Application No: R/90/22/HH
Site Address: Kingfishers 10 Fosters Close Rustington BN16 2TL
Description of works: Single storey side garage extension, front porch extension, hip to gable loft conversion including the installation of front dormers and rooflights and alterations to fenestration/openings.

Thank you for your internet representation made on 15th May 2022 which has been recorded as an objection with the comments as follows:

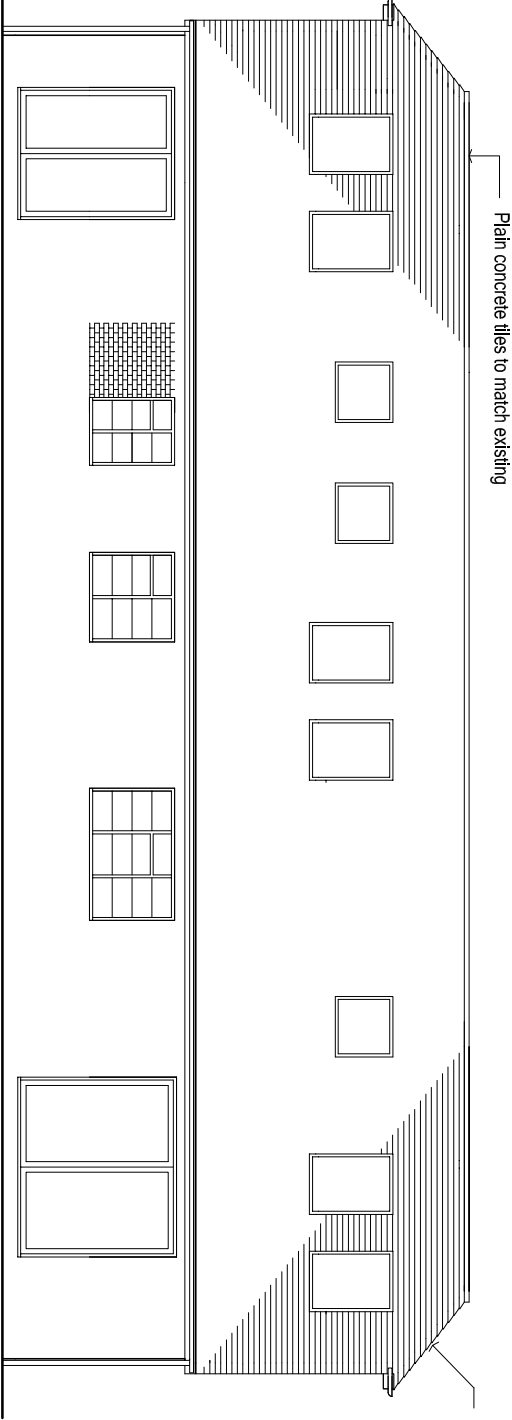
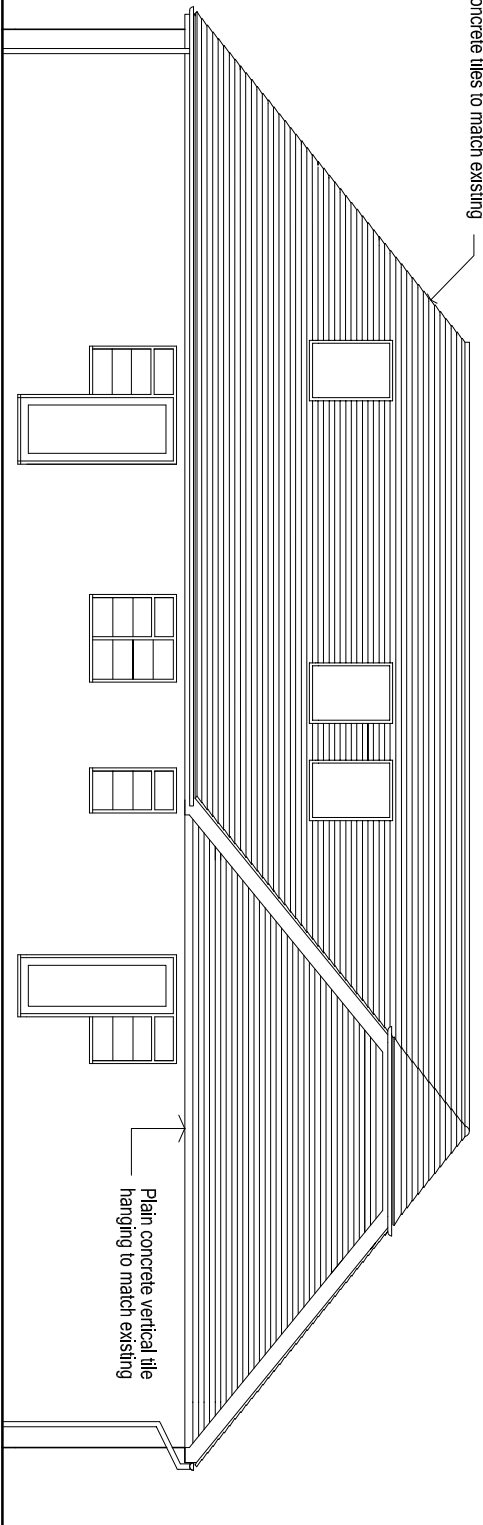
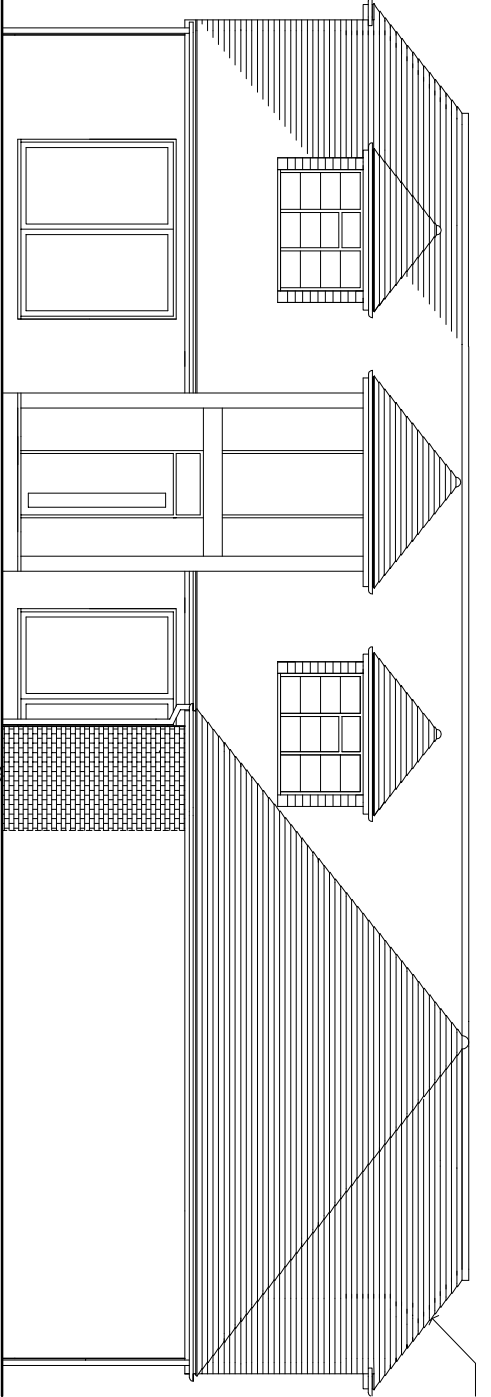
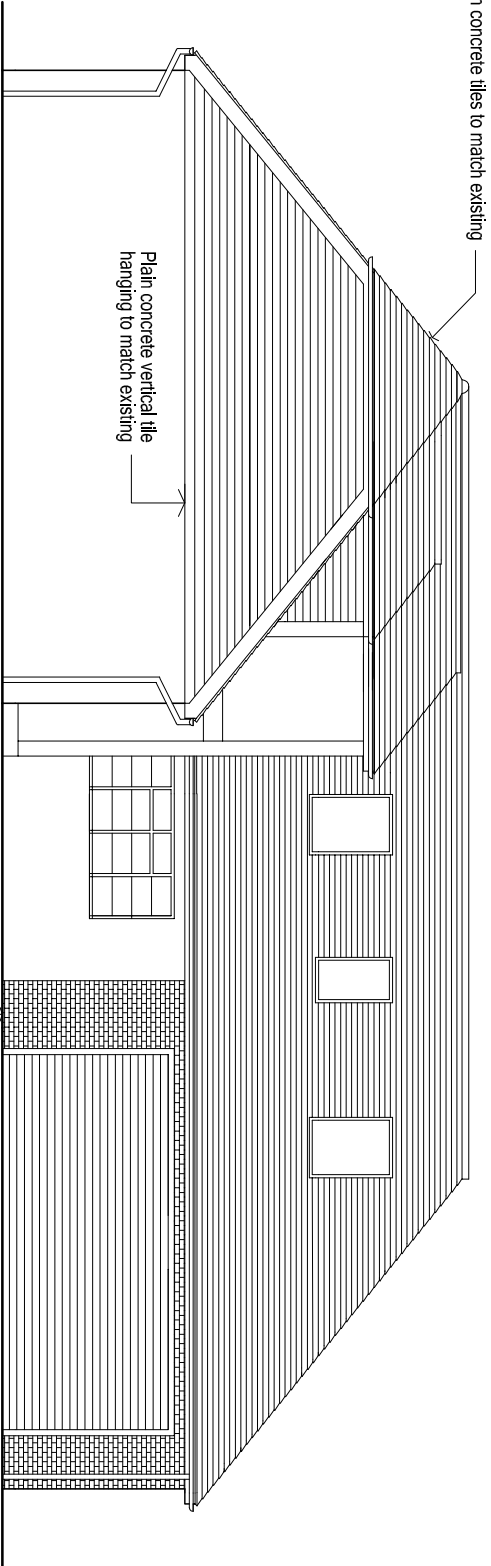
My objection relates entirely to the windows. The three Velux windows on the east elevation will look into my bedroom windows. I consider this to be an invasion of my privacy. In fact, my windows will look into the windows of No.10, something I'm sure the new owners would not want. There are two bedrooms on the upper floor of that part of the plan and both have conventional windows on the west elevation providing more than adequate light. The Velux windows on the east elevation are totally unnecessary.

I also object to the Velux windows, of which there are nine, on the north elevation. I consider this to be an excessive number of windows. My garden extends to (and is adjacent to) the rear of No.10 and these windows will look directly into it, again destroying my privacy. The rear garden of No.10 is extremely short and the property is therefore very close to my boundary. This exacerbates the problem of my garden being overlooked. Also, windows overlooking my property probably devalue it.

DRAWING TITLE:
PROPOSED FIRST FLOOR PLAN
PROJECT:
LOFT CONVERSION WITH HIPPED TO GABLE ENDS, DORMERS TO FRONT ELEVATION & GARAGE
EXTENSION WITH RAISED RIDGE

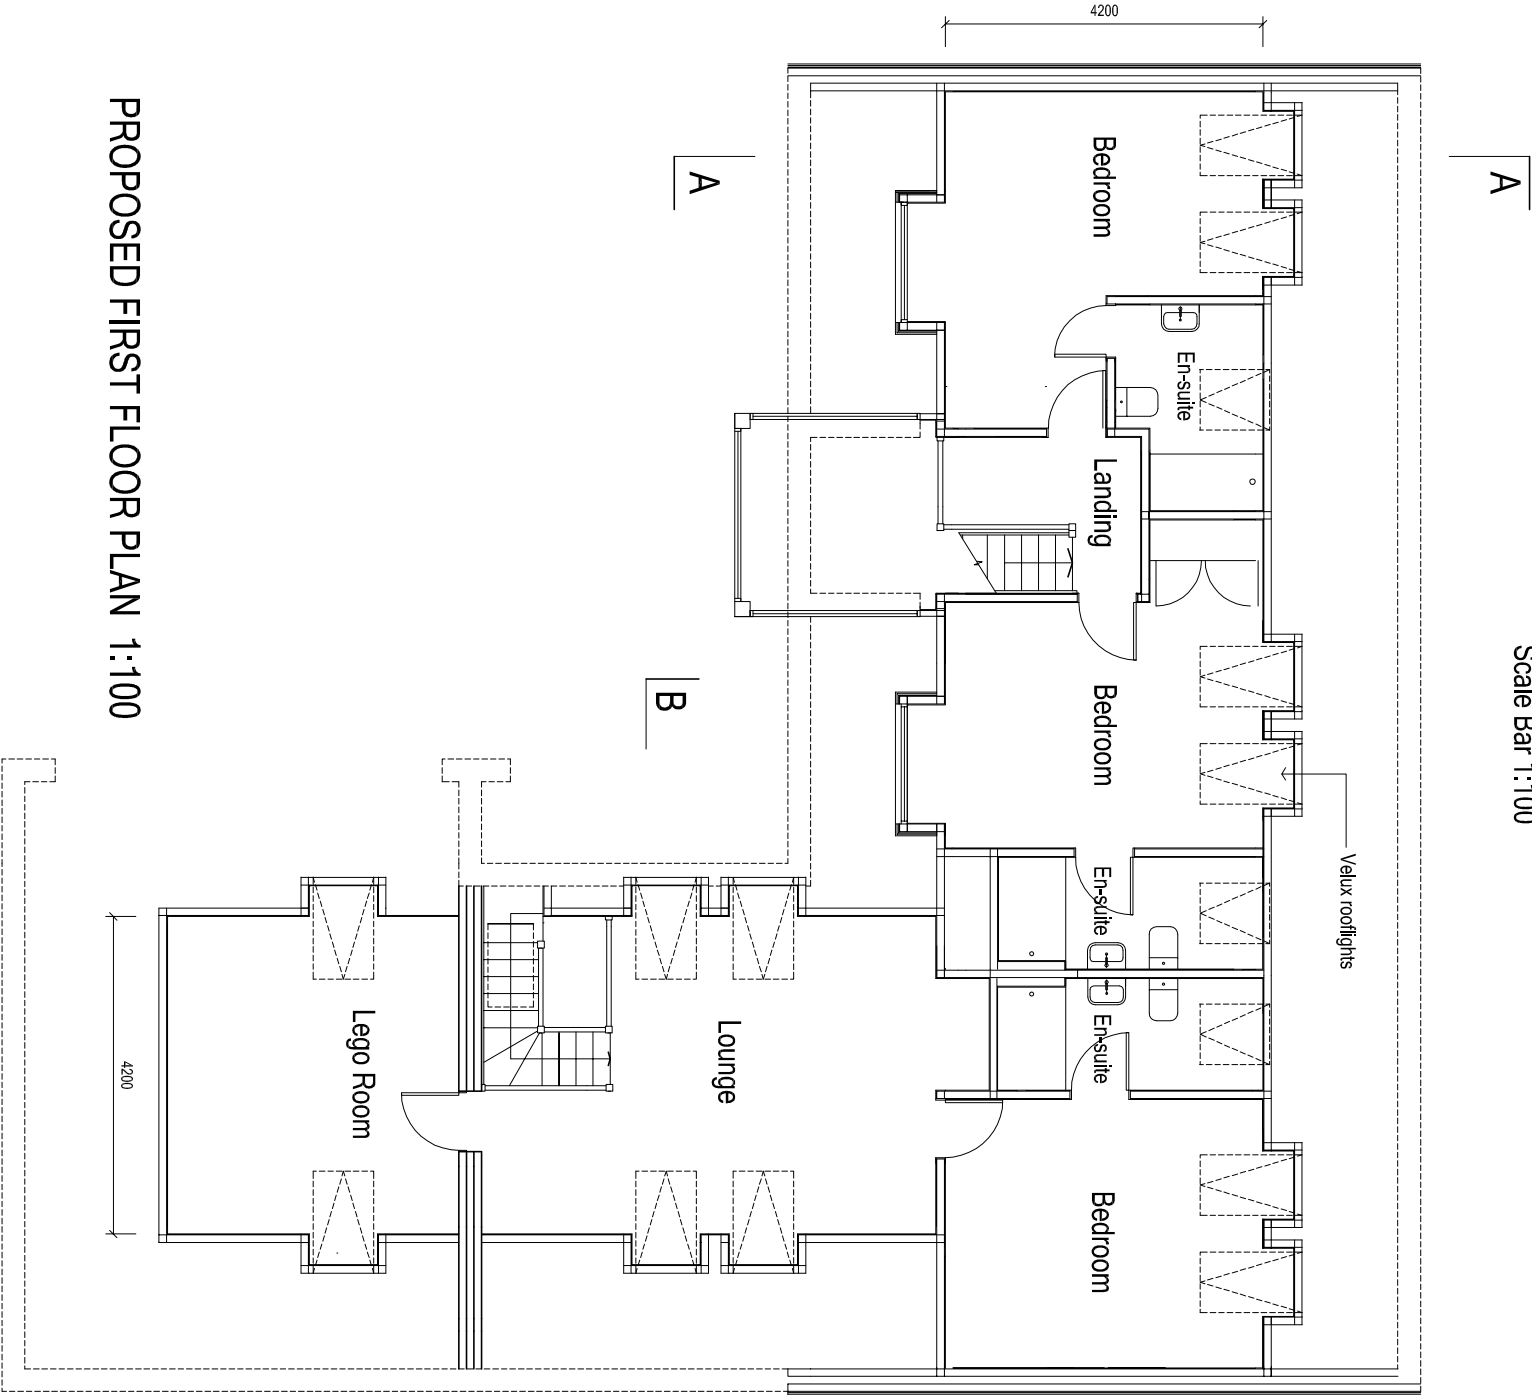
Two bedrooms on the first floor have conventional windows on the south elevation. Again, there is no reason why these two bedrooms require extra lighting from the north elevation. There are three en-suite bathrooms with Velux windows on the north elevation. These could easily be fitted with extractor fans rather than windows as so many properties have these days. The third bedroom on the upper floor only has windows on the north elevation. However, as a gesture of goodwill, the new owners could consider installing windows in this room with obscured glass.
